Reference: 12S1395000

28 November 2014

**RE: CENTRAL PARK, BROADWAY – BLOCK 1 STATE SIGNIFICANT
DEVELOPMENT APPLICATION FOR A MIXED USE BUILDING (SSD 6554)
AND MODIFICATION TO THE PROJECT APPROVAL FOR COMMERCIAL
DEVELOPMENT ON BLOCKS 1 AND 4N (MP08_0253 MOD 5)**

This letter provides a response to the traffic and transport related issues.

Figure 2.2: Amended Concept Plan

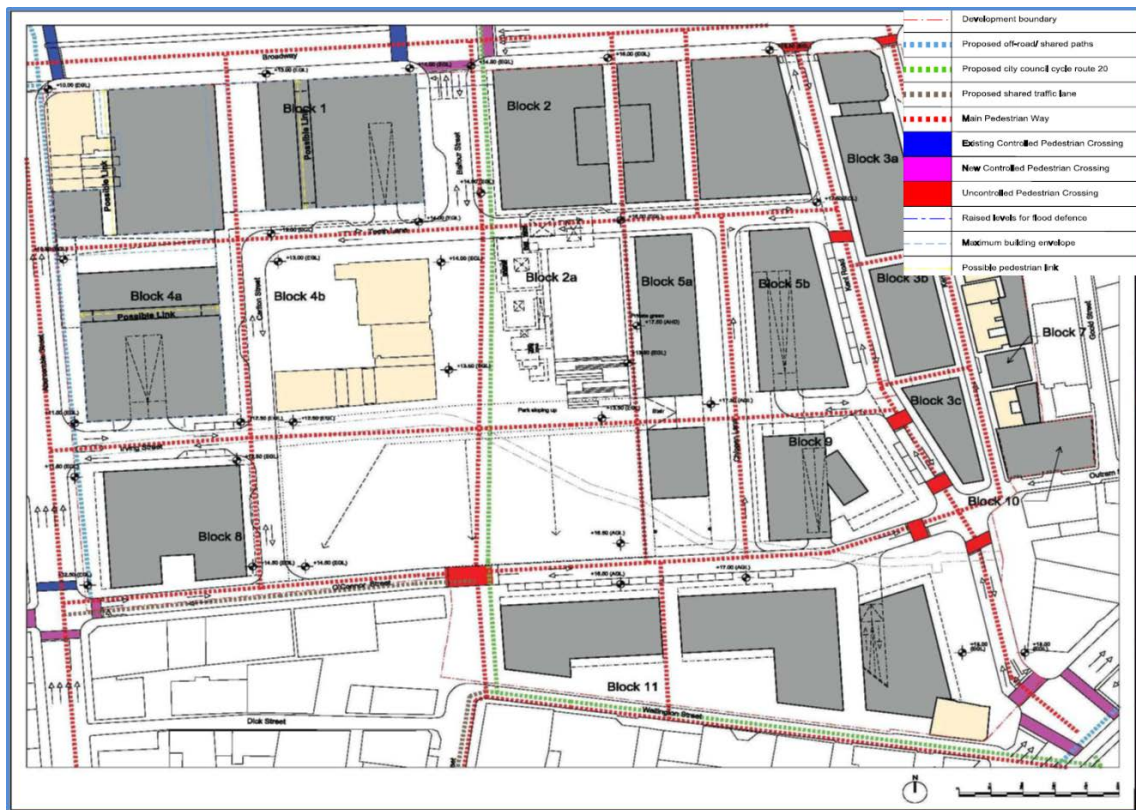
In addition, in their submission the City of Sydney contended that the vehicular access into Block 1 basement car park should be from Abercrombie Street and for the “secondary” access from Central Park Avenue to be deleted.

The above statement is incorrect. The approved Concept Plan does not include a vehicular access off Abercrombie Street. Developments within Blocks 1 and 4 have always been approved with a single access off Central Park Avenue. Reference to this as secondary access is not correct.

The concept plan as approved in MP 06_0171 (MOD 2) is re-produced below as Figure 1 (this figure was also included in the transport report that accompanied the SSDA).

In accordance with the Infrastructure SEPP, access for general traffic is to be provided off non-classified road where the site has frontage to a non-classified road. The development site has frontage to both Abercrombie Street which is a classified road and Central Park Avenue which is a non-classified road. Therefore, in this case general vehicle access will be provided from Central Park Avenue in accordance with the Infrastructure SEPP and the approved Concept Plan.

Thus in conclusion, we submit that it is not possible to obtain approval from the road authority for a vehicular access from Abercrombie Street for general vehicles. Furthermore, direct general vehicle access via Abercrombie Street is not a desirable traffic outcome and is not consistent with the approved Concept Plan. It is noted that the proposed SSDA access arrangements are consistent with the approved Concept Plan and are appropriate for the proposed development.
